Intermodal Logistics Centre at Enfield

Modification Application No. 6 ECI Detailed Design Adjustments and Subdivision

Response to Submissions

Appendix A:
Submissions

Figure 3 – Proposed Site Layout

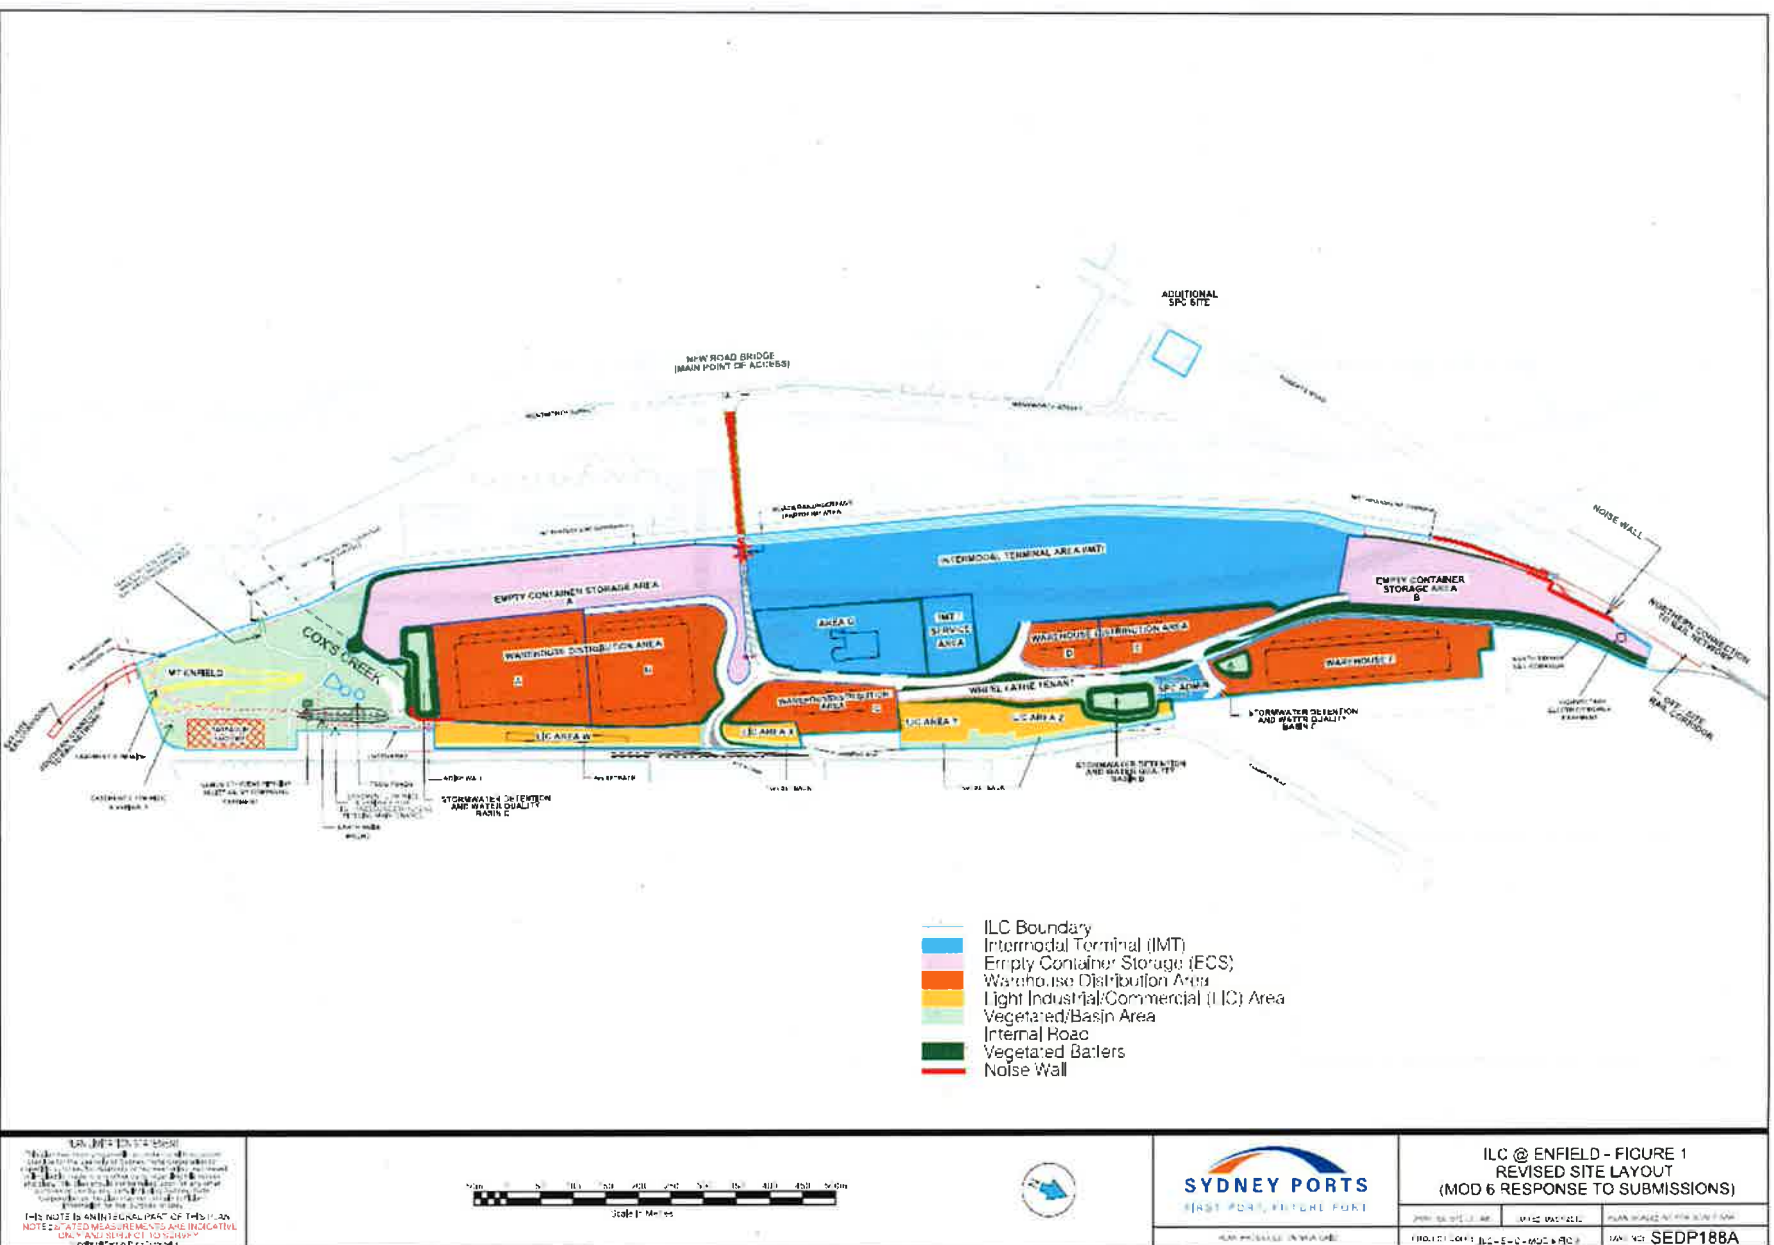
The EPA also notes that the proponent states that container handling will not be undertaken in the area surrounding the high voltage power line tower, but that this area is still included within the 'Empty Container Storage Area B' shown on Figure 3 of the Modification Application documents, and will be included as part of the lease for the Empty Container Storage Area B (page 13). The EPA is therefore concerned that there are currently no measures in place that will ensure that the area surrounding the high voltage tower will not be used for container handling or other noisy activities.

1. The Revised Site Layout (refer Attachment 5) for Modification Request No 6 does not indicate or label the 'Community and Ecological Area'. Council requests that the Site Layout Plan be amended to be consistent with the original 5/9/07 project approval for Enfield ILC ie. the precinct south of Coxs Creek including Mt Enfield, Tarpaulin Factory, Frog Ponds should all be labelled 'Community and Ecological Area' and coloured accordingly eg. light green.

The general landscape area (not including the 'Community and Ecological Area') indicated in the Modification Request No 6 'Revised layout Plan' (refer attachment 5) clearly has been significantly reduced from the original approval and from previous modification requests. Council

Figure 5 – Revised Plan of Subdivision

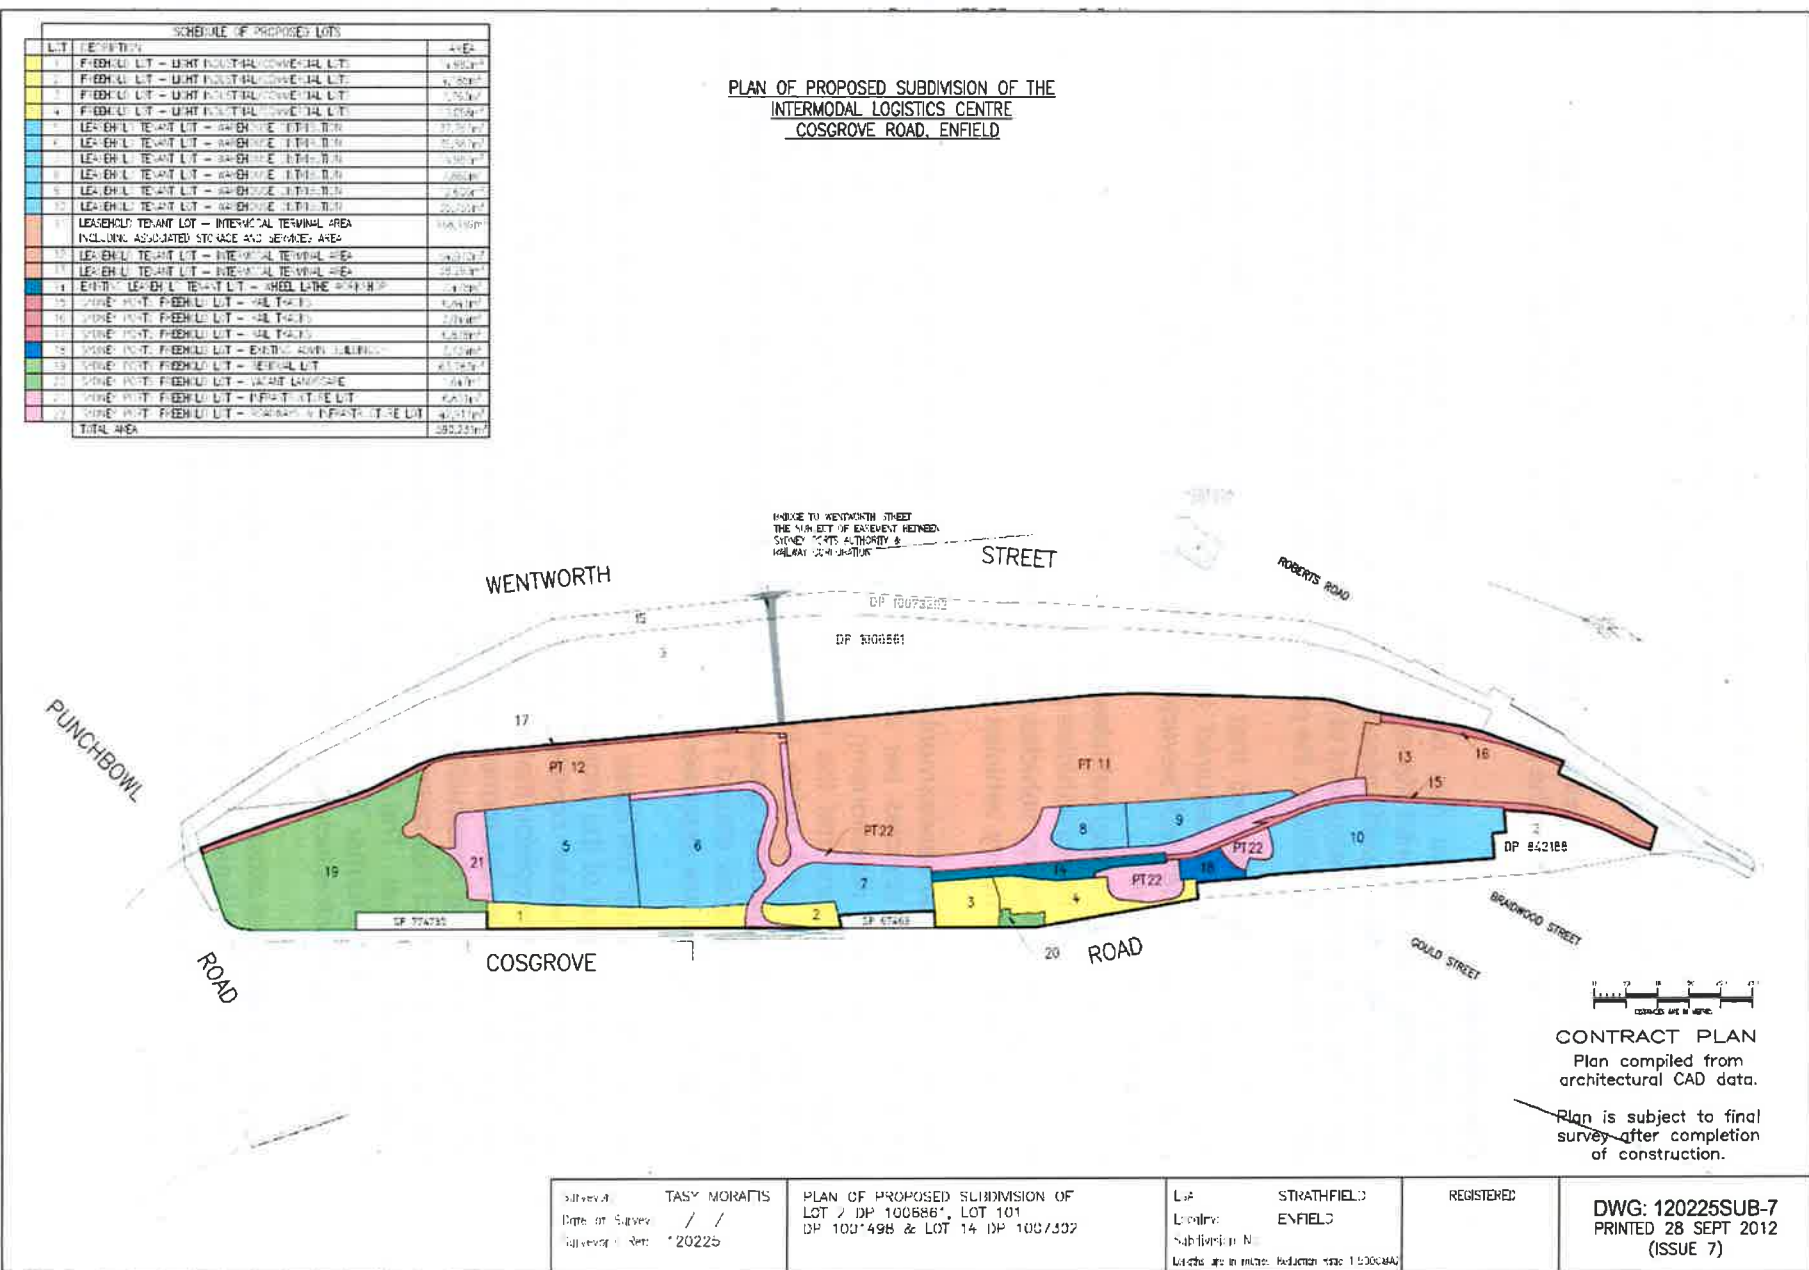
1. The proposed subdivision pattern (refer Attachment 6) conflicts with the intent of the original approval for the southern section of the site becoming a 'Community, Heritage and Ecological Area'. The subdivision plan proposes to subdivide the 'Ecological & Community and Heritage Area' into three lots being: Lots 19, 20 and 25. There is no advantage or logical justification provided in the modification request to divide up the 'Ecological & Community and Heritage Area' which is a key component of the original Project Approval. Subdividing Lot 19, 20 and 25 undermines the preservation of this area especially as it creates potential opportunity for the sale or leasing, particularly of Lot 19 which includes the area at the corner of Punchbowl Road and the Tarpaulin Factory.

The subdivision that creates Lots 19, 20 and 25 is a considerable change that is not supported by Council because it potentially diminishes the amount of land originally dedicated in the original approval for community, ecological and heritage purposes. This precinct should be protected by retaining the land to the southern side of Coxs Creek as one lot. Operational issues for this area such as controlled access to the frog habitat and to the steeper areas of Mt Enfield and whether the Tarpaulin Factory remains on site or is relocated, do not impact on preserving this whole area as a 'Ecological & Community and Heritage Area'.

Figure 4-2d
Design Layout - Landscape

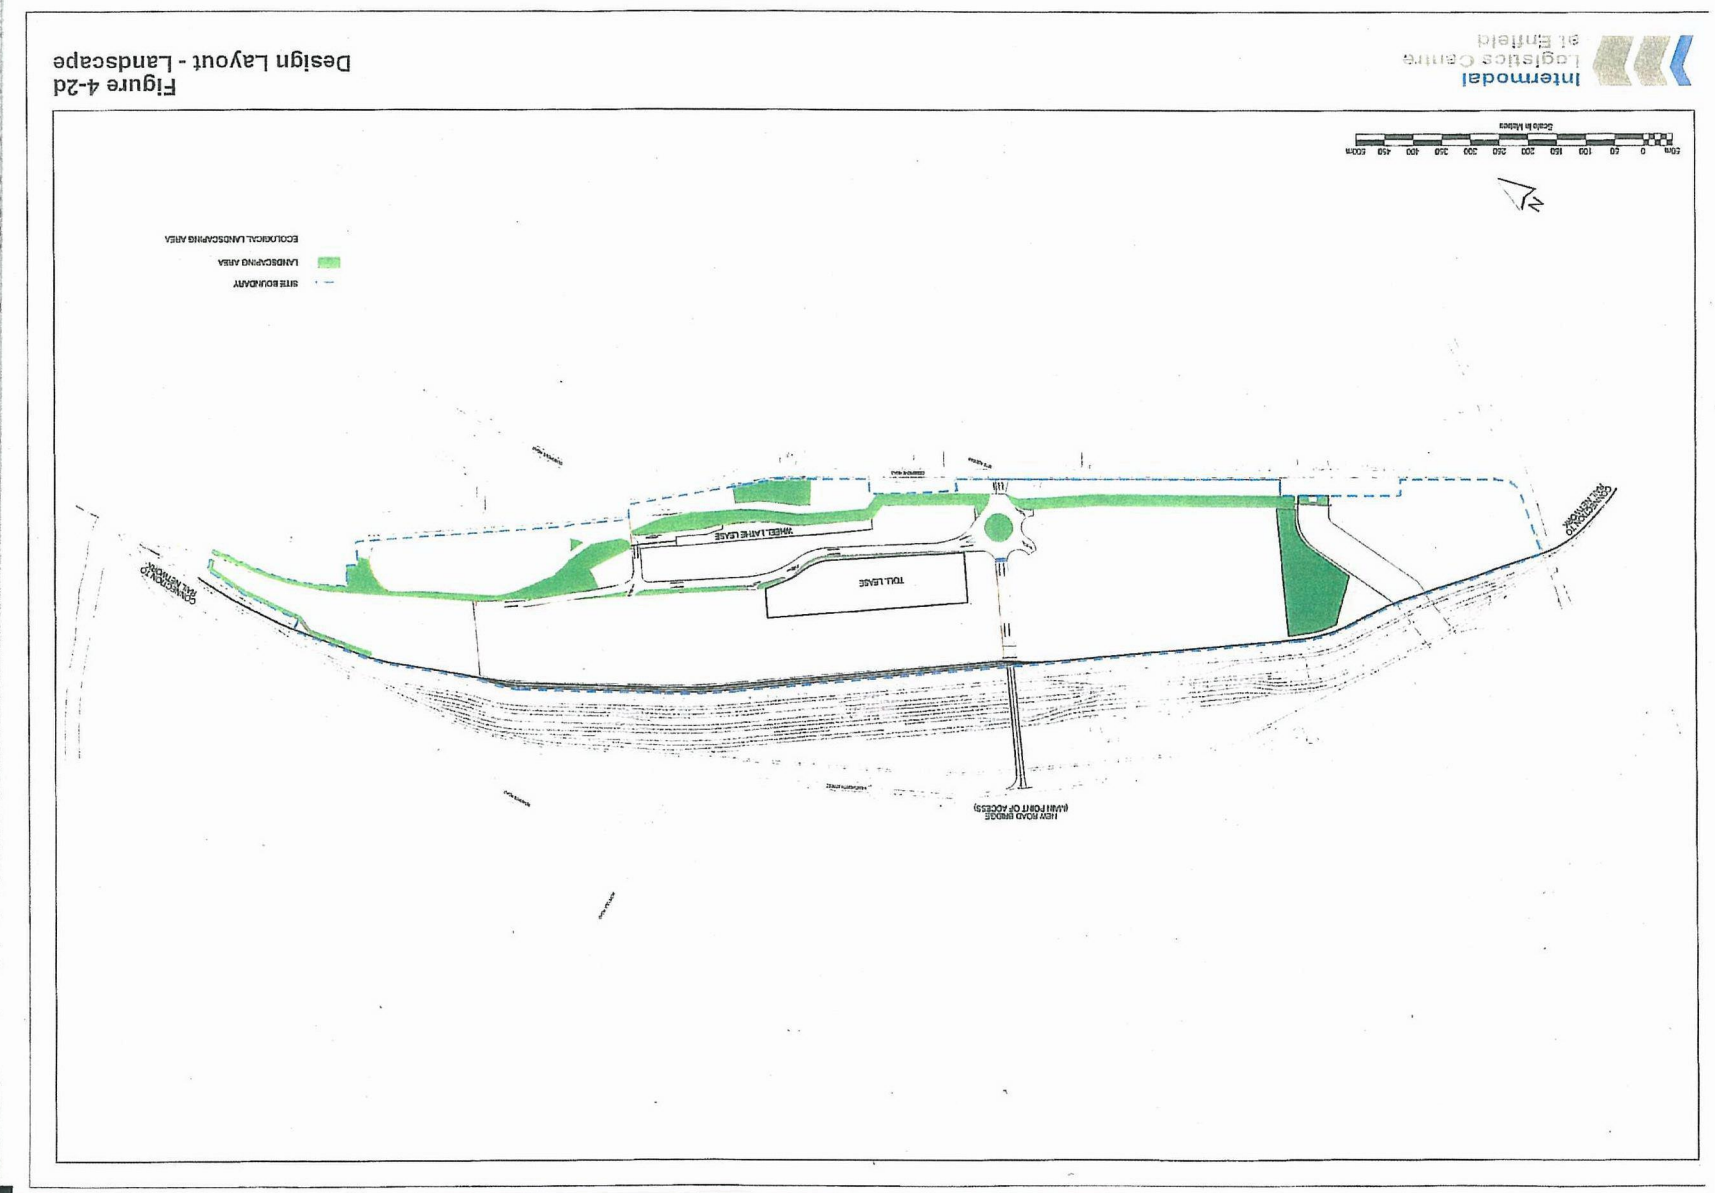
For instance Attachment 2 and Attachment 3 clearly indicate the amount of landscape area across the site (not including the 'Community and Ecological Area') in accordance with the Project Approval. However the gradual reduction in general landscape area is evident in Attachment 4 which appears to be as a result of Modification request No 1 & 2.
